## Application for a Non-Material Amendment Following a Grant of Planning Permission

Wallasey Crescent

38946/APP/2022/376

Squaring-off the rear elevation by the dining room.

PROPOSED GROUND FLOOR PLAN
1:50@A3

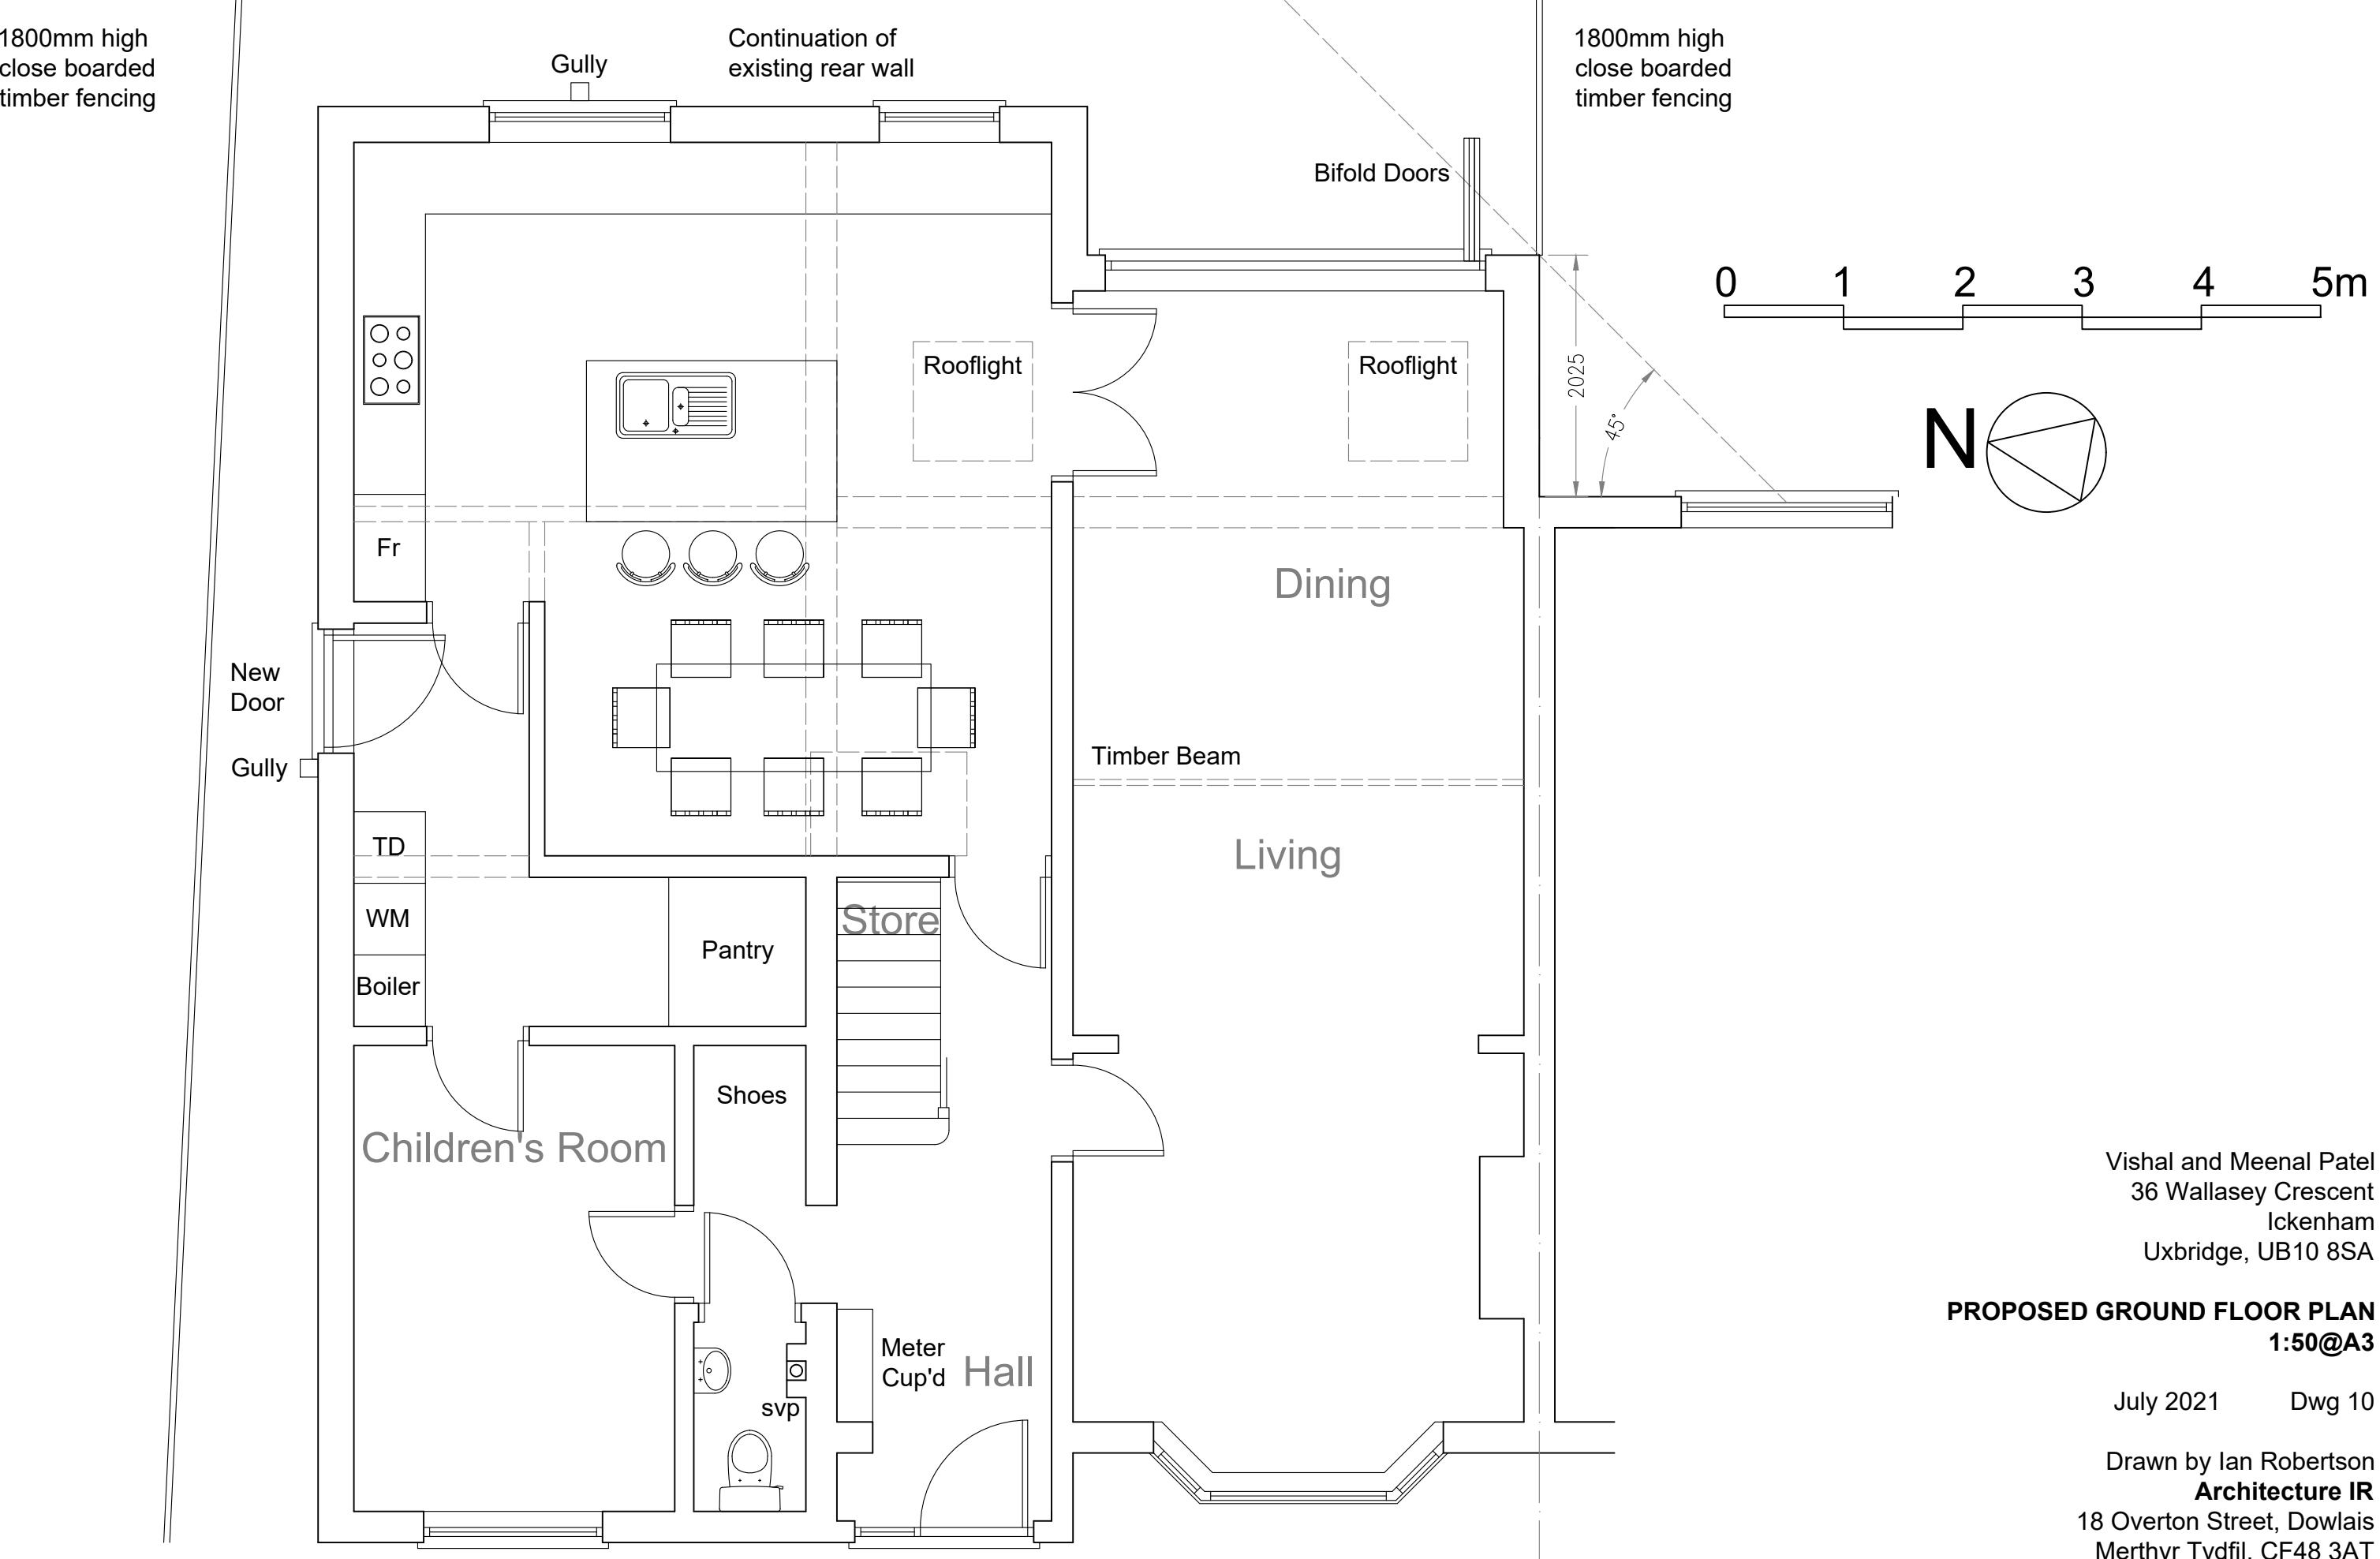
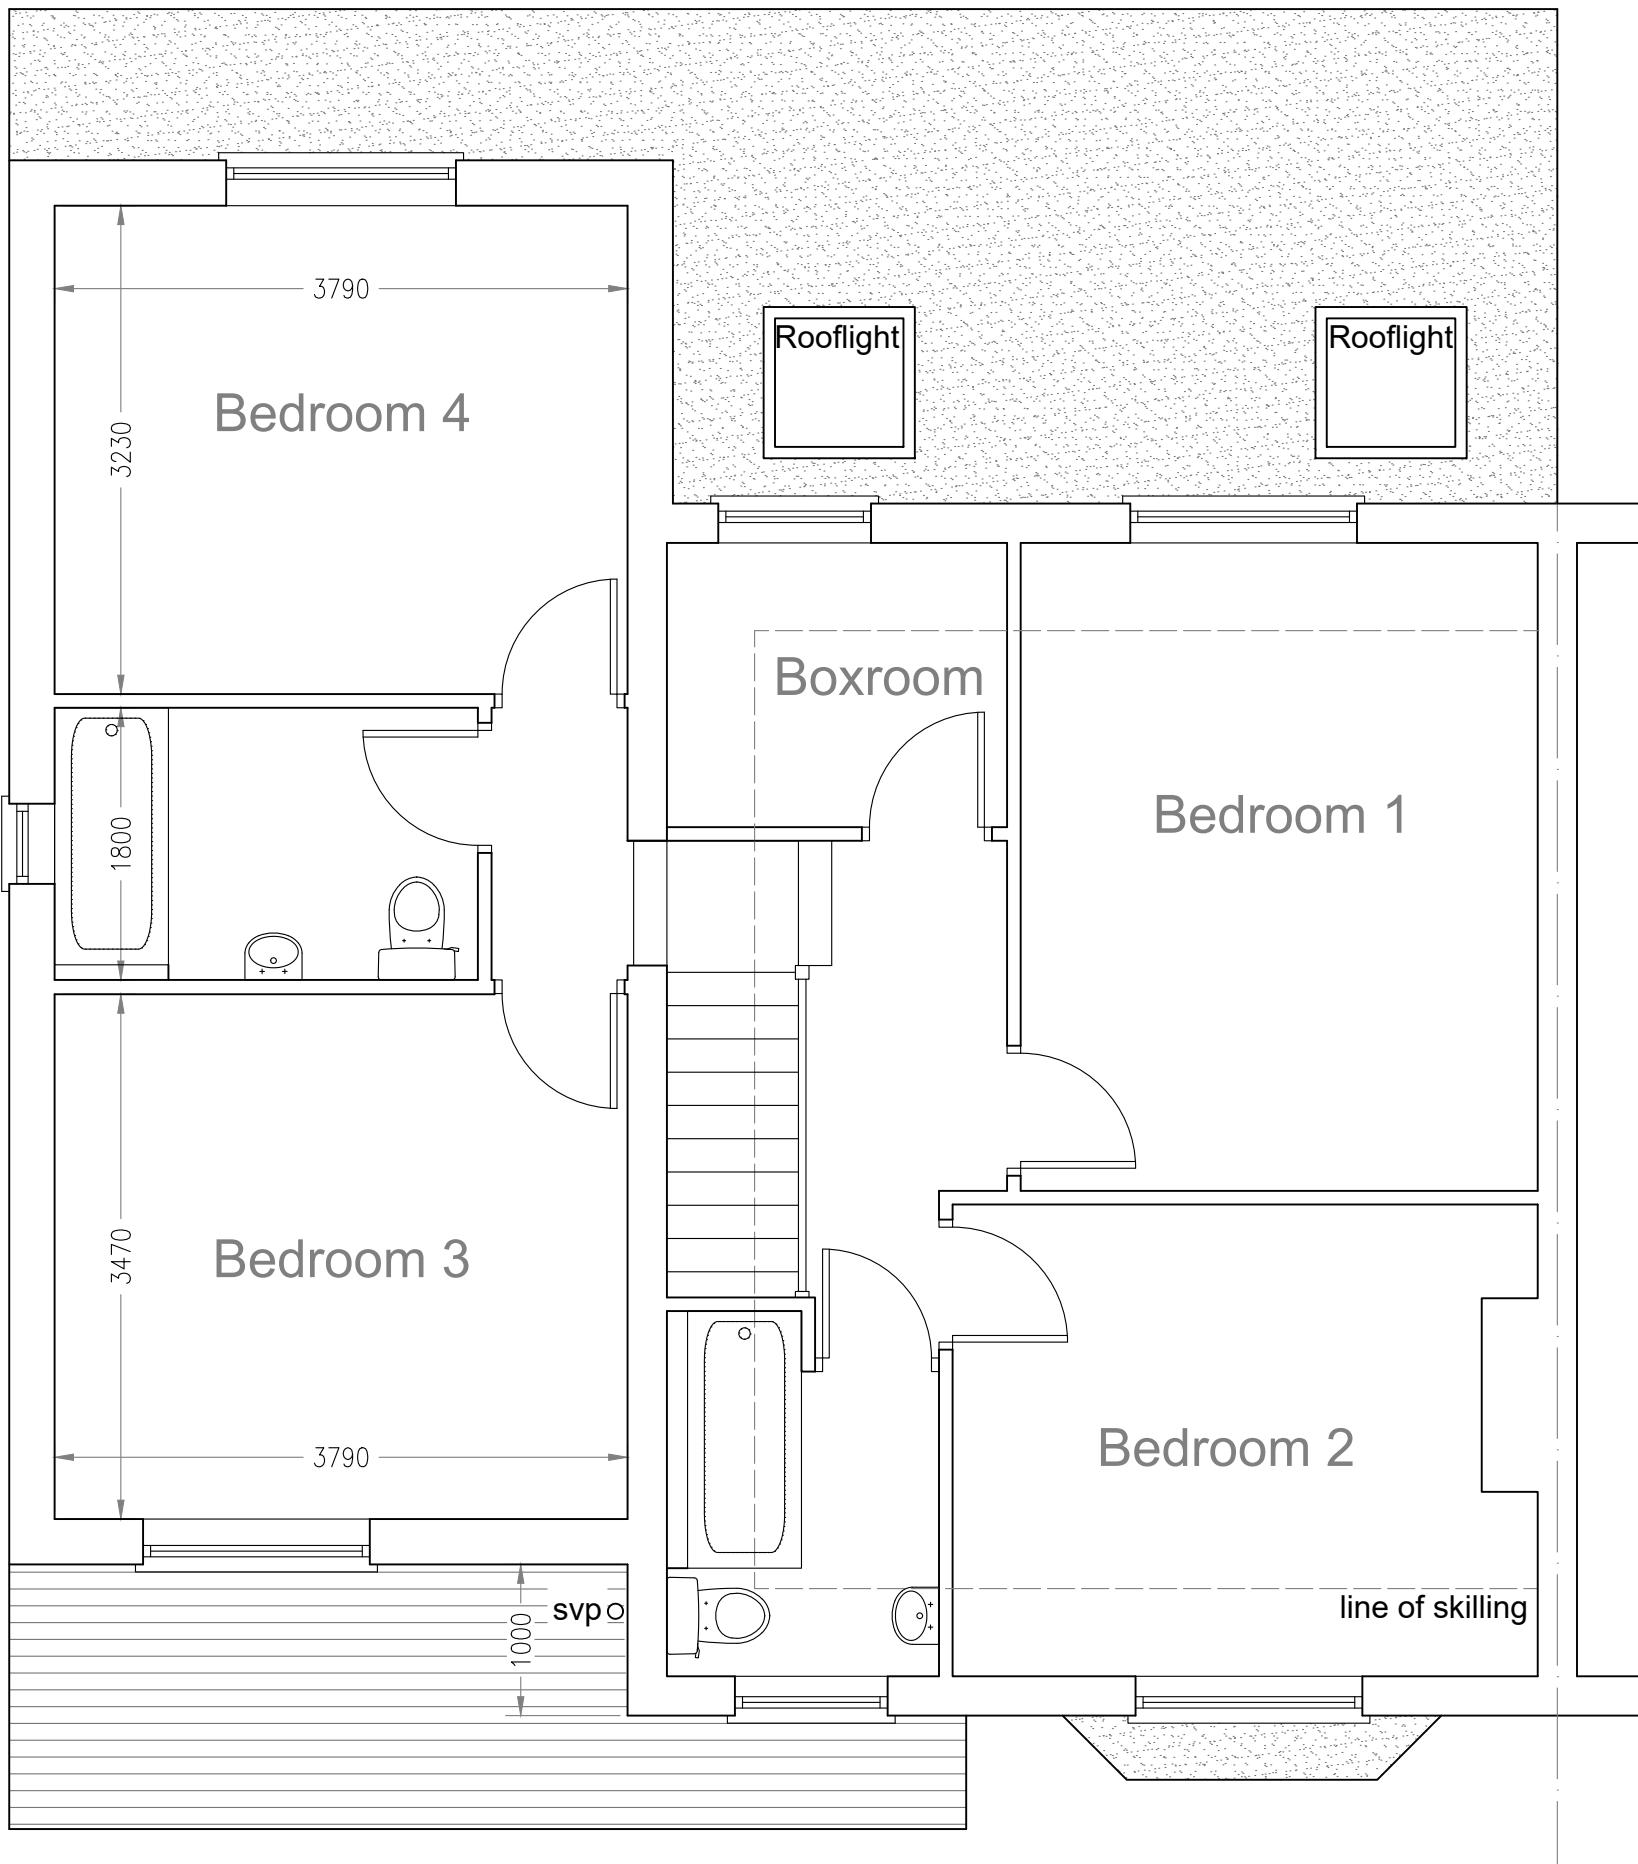
The original step in the rear elevation is believed to be a misunderstanding of the application of the 45-degree rule as applied to the windows of No.34. The rule only applies to two-storey extensions.
